Martin Nugent
01254 828060
D3/12/0728

Drafted 26 September 2012

**Planning Application, Ribble Valley District
3/12/0728 Salem Congregational Chapel, Martin Top, Rimington**

PROPOSED RAMP FOR DISABILITY ACCESS

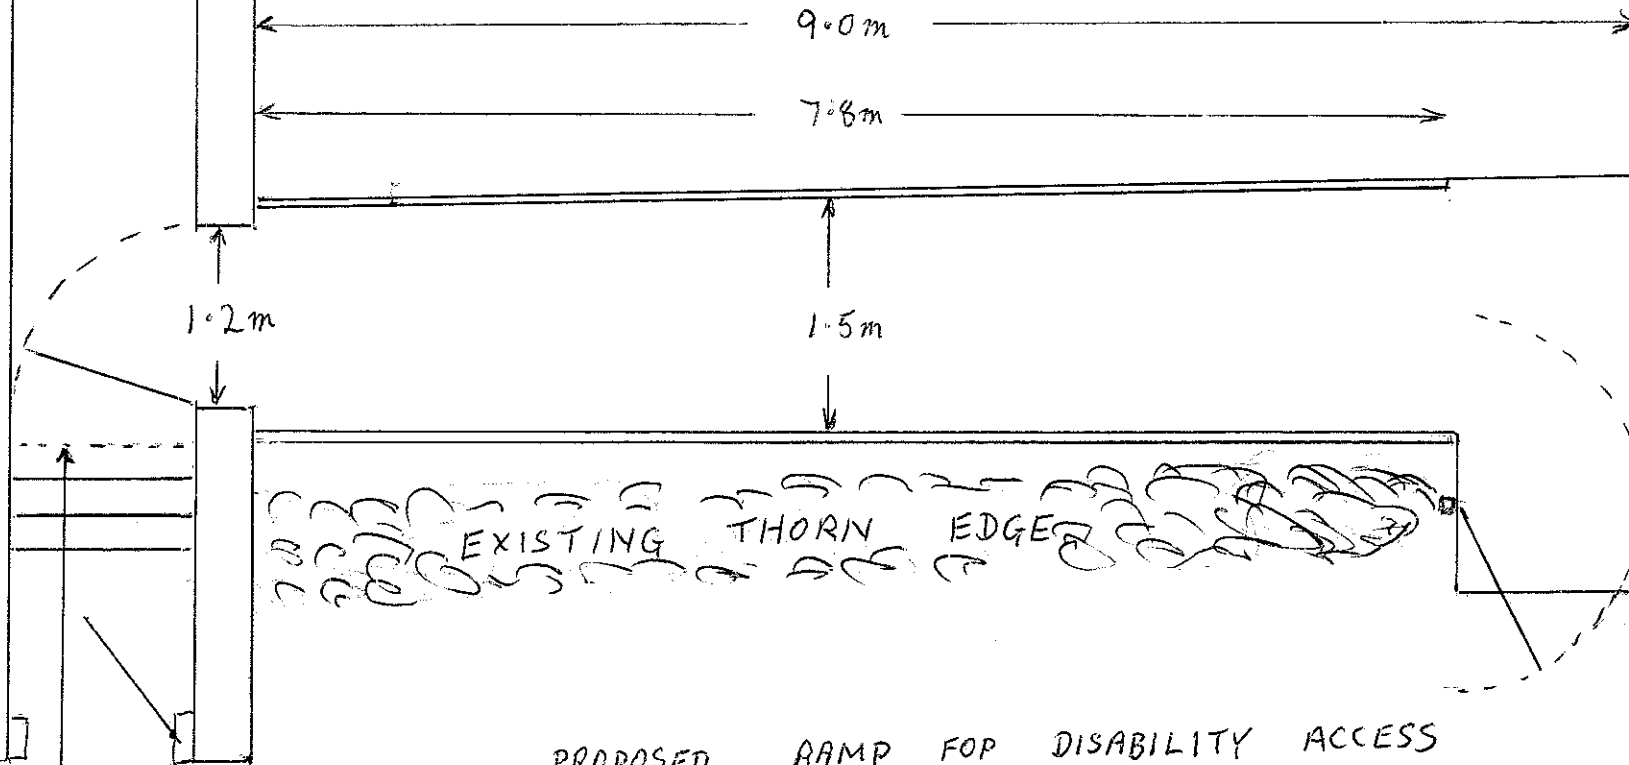
I have no objection in principle to this application on highway safety grounds.

The proposed access takes a convenient route from the parking area to the main building via a new external doorway. The gradient of the path will accommodate all users and is separated from the parking area by means of an established planted area.
